In reply please quote: 20/05386

SSD-10436 (MOD 2) – REQUEST FOR ADVICE FOR PROPOSED AMENDMENT TO LOT 202 TO 6 JOHNSTON CRES, HORSLEY PARK (ESR HORSLEY LOGISTICS PARK)

Fairfield City Council is in receipt of the Department's request for advice dated 14 September 2021 on the Modification Report prepared by Urbis dated 30 August 2021 and supporting technical studies for SSD 10436 (Mod 2).

1 Site Facilities Plan - (Lot 202)
202-A200 1: 500 @B1

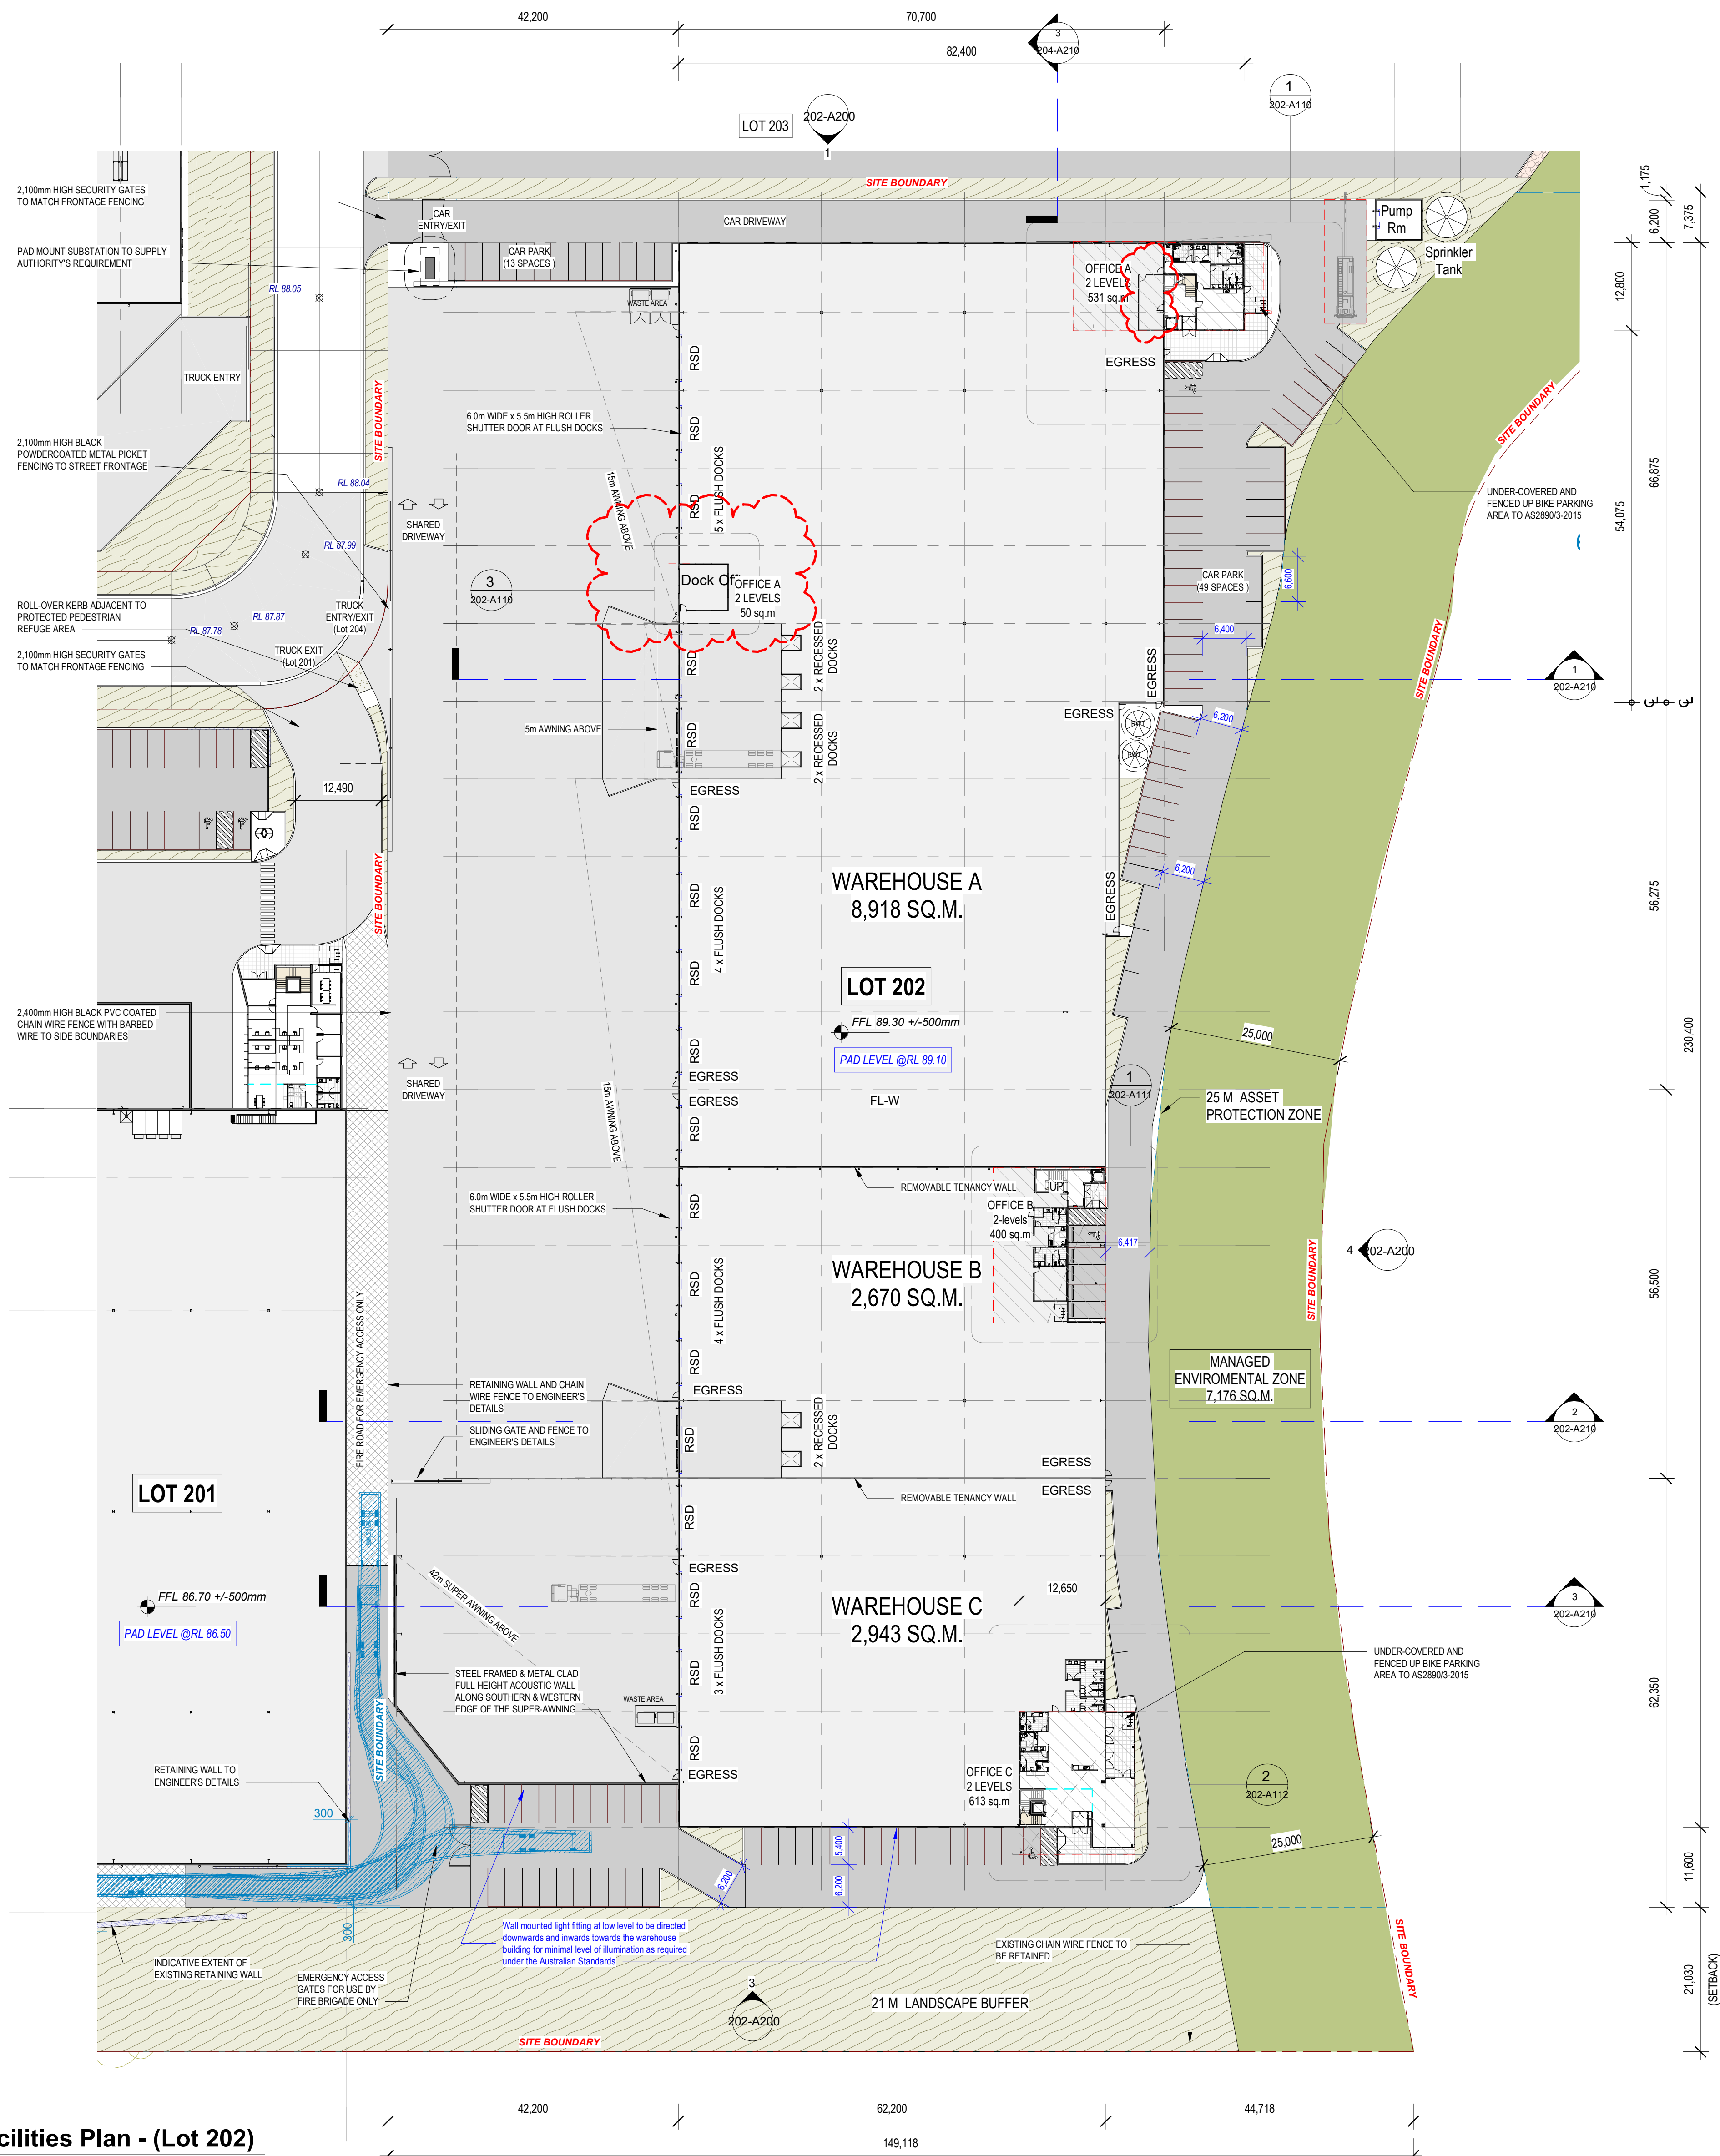
- Turning path diagram (AG07) indicates that a 12.5m long heavy rigid vehicle entering "Lot 202 warehouse A" from Lot 201 requires to use the entire northernmost driveway in order to exit the site. As the northernmost driveway of the site is designed as a combined entry/exit driveway, potential conflicts between vehicles entering and exiting the site at the same time shall be addressed.

- Turning path diagram (AG07) indicates that a 12.5m long heavy rigid vehicle entering "Lot 202 Warehouse A" from Lot 201 requires to manoeuvre through the car parks to exit the site. Any potential conflicts between the heavy rigid vehicle and passenger vehicle shall be addressed particularly at intersection area/bend where it can only accommodate one HRV at a time. Additional information shall be submitted to Council to address this concern.
